**WELWYN HATFIELD COUNCIL – DEVELOPMENT CONTROL**  
**DELEGATED REPORT**

<b>APPLICATION No:</b>	<b>S6/2011/1624/LUP</b>
------------------------	-------------------------

**DESCRIPTION OF PROPOSAL:** Certificate of Lawfulness for the proposed erection of detached garage/playroom and extension to existing driveway to form access to building

Drawing Title: LOCATION & BLOCK PLANS **A2**
 Project: GARAGE & GAMES BUILDING
 Client: MR DAKERS
 Address: WELLS FARM NORTHAW ROAD EAST CUFFLEY
 Drawing No. 02/122/11 Date: JUNE 11

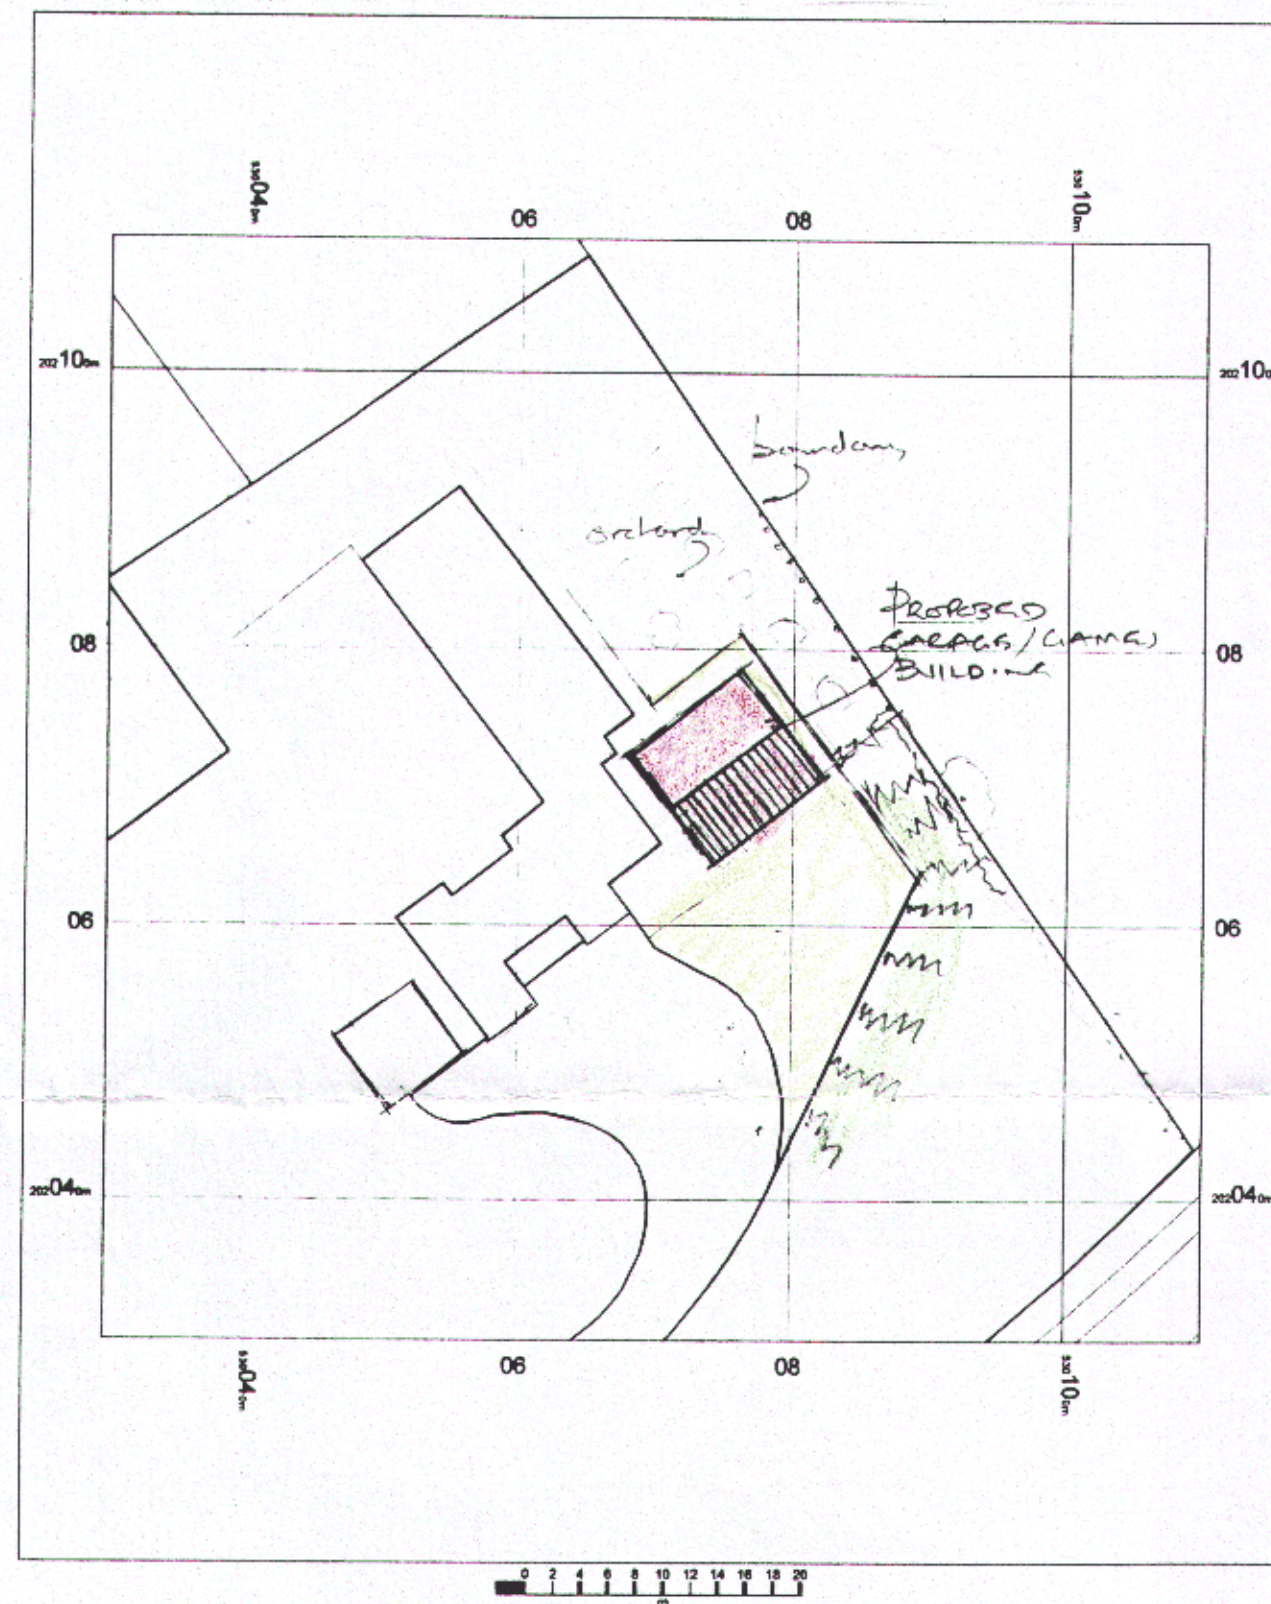
*Hardsurfacing is surrounded by soft landscaping areas and thus run-off water will be channelled to a porous surface.*

Drawing Title: ELEVATIONS A2
Project: GARAGE & GAMES BUILDING
Client: MR. D AKERS
Address: WELLS FARM NORTH LANE RD EAST CUFFLEY
Drawing No. 03/122/11A Date: JUNE 11

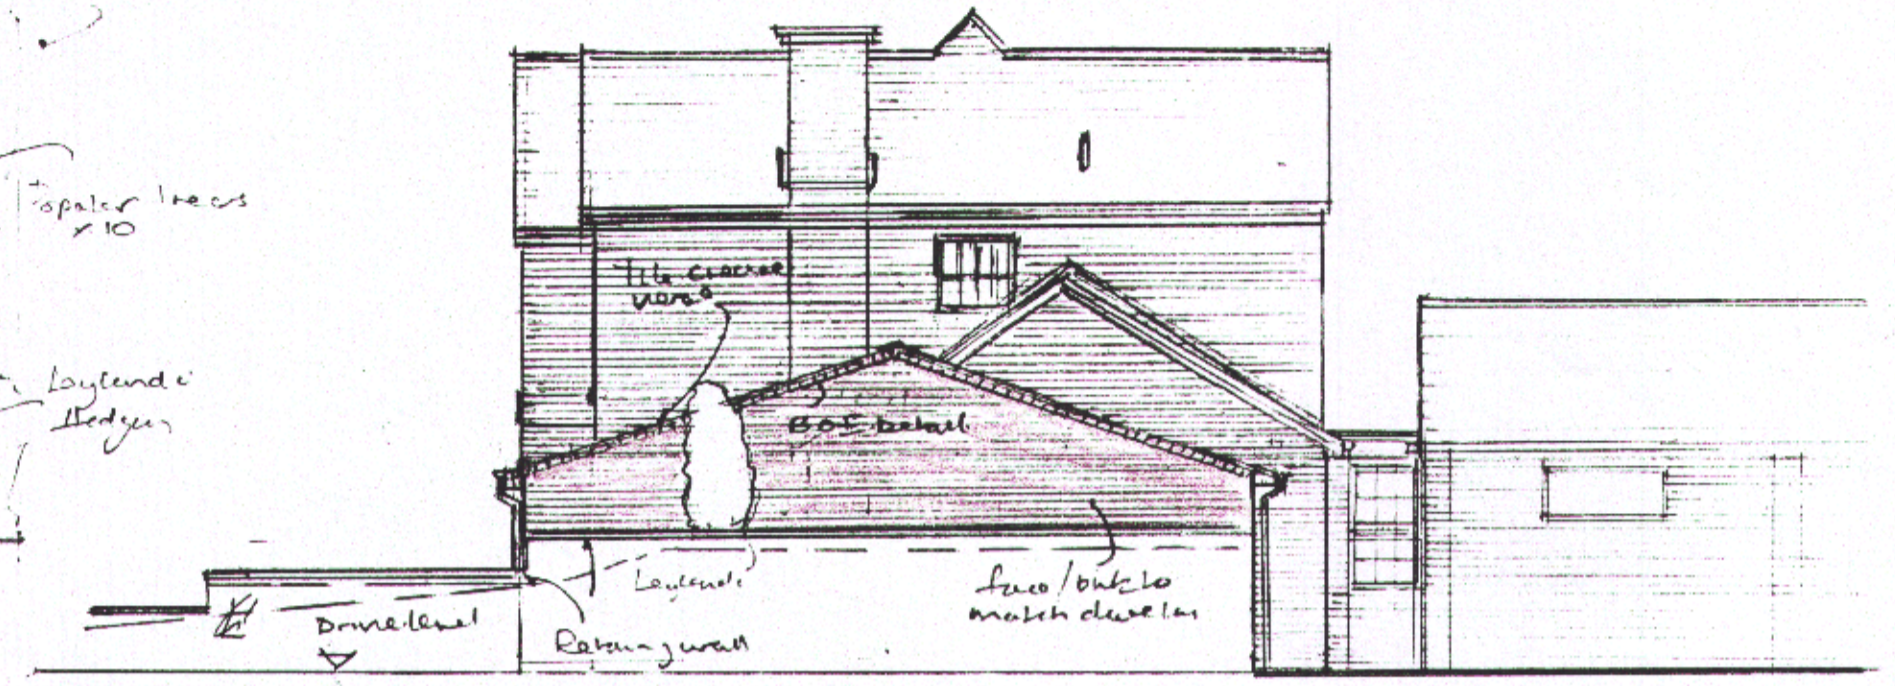
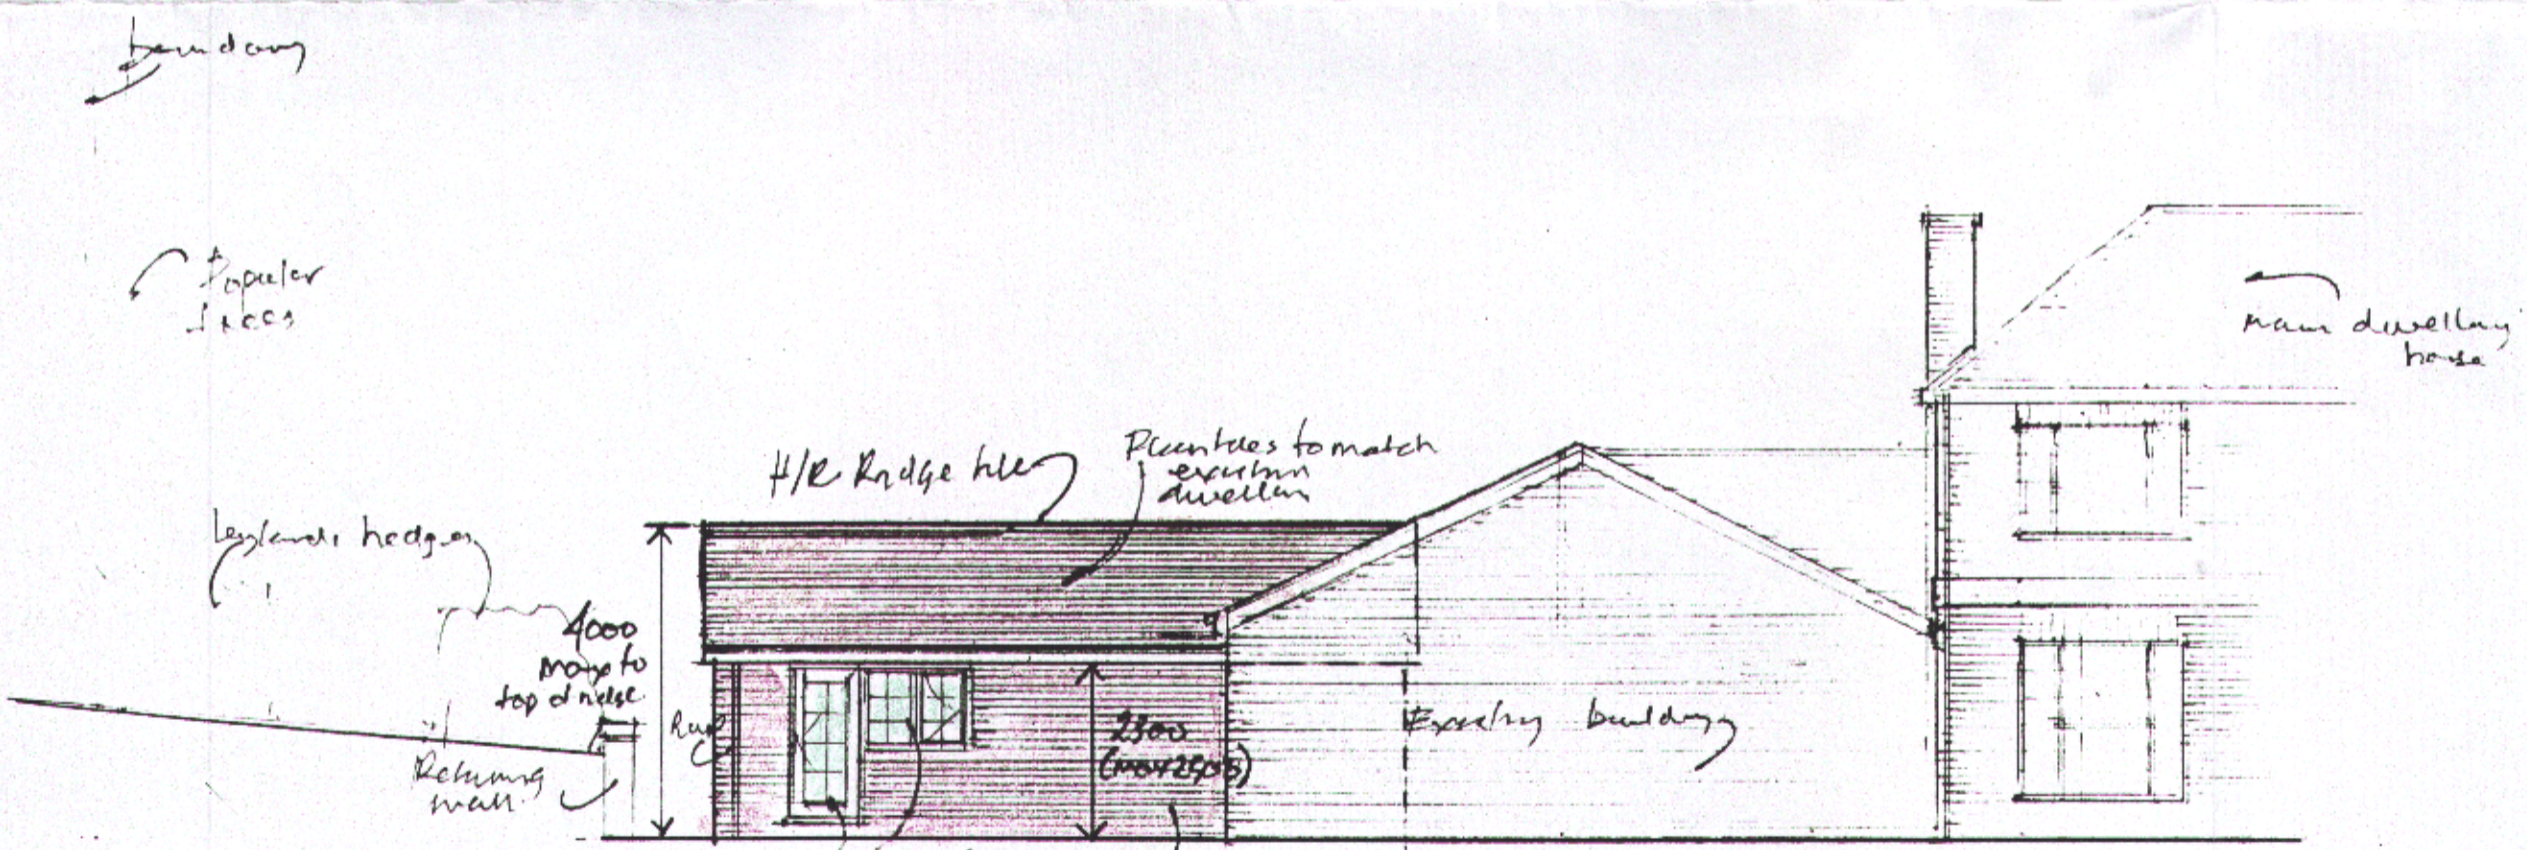
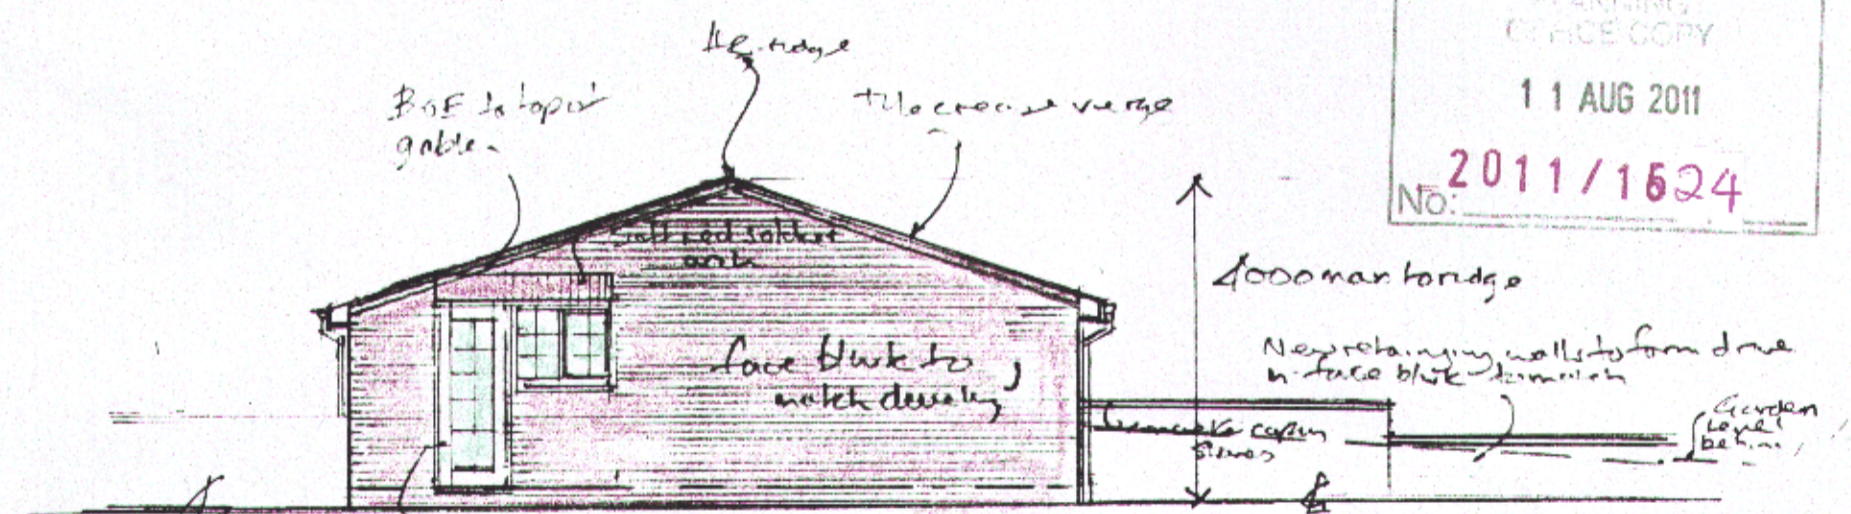
The height of the building is less than 4 metres and is more than 2 metres away from the boundary.

The height of the eaves is 2.5metres
